**From:** Bernadette Owens  
**Sent:** 26 November 2020 14:50  
**To:** DC Support  
**Subject:** Objections to Application 20/02779/REM

These comments relate to 20/02779/REM, a reserved matters planning application relating to a development that is part of Bicester 10. We have the following objections:

Figure 4.1. Site Access

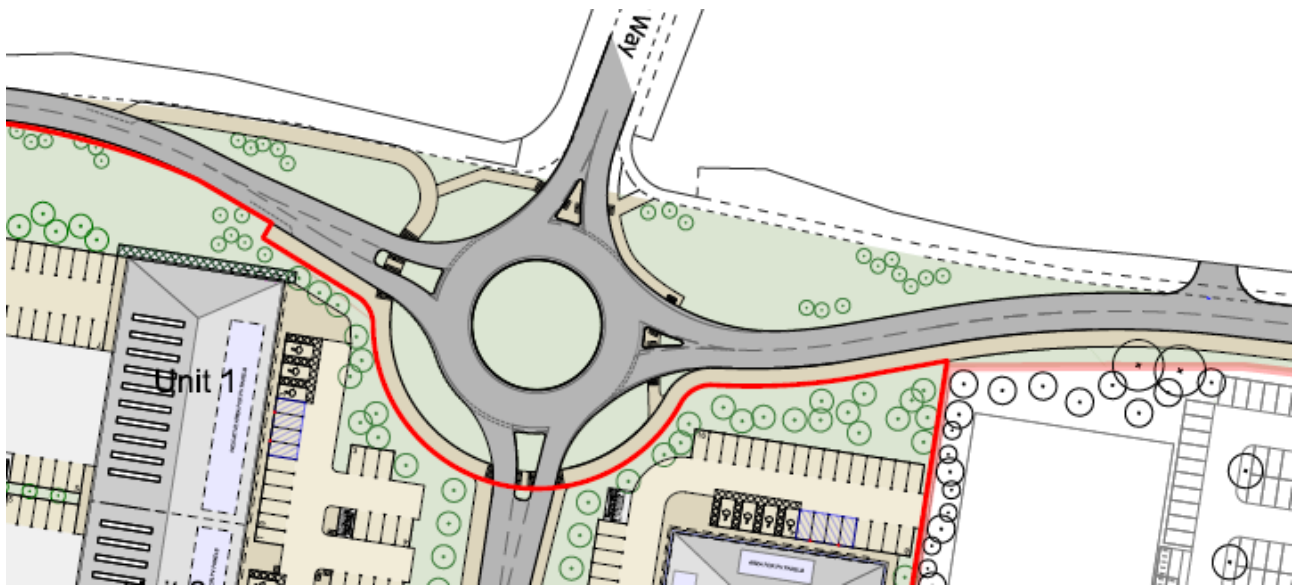
The roundabout makes no provision for crossing points for pedestrians or cycle users. This will encourage vulnerable cycle users into the vehicular carriageway where they will be at risk from heavy industrial vehicles. The Local Walking and Cycling Infrastructure Plan for Bicester 2020 requires now in force requires that roundabouts be designed according to so-called 'Dutch' design.

The roundabout ought to be designed at the minimum as a rural Dutch roundabout without priority for cyclists with suitable crossing points, waiting areas that do not obstruct the movement of pedestrians and cyclists, and a circular path for cycle movement.
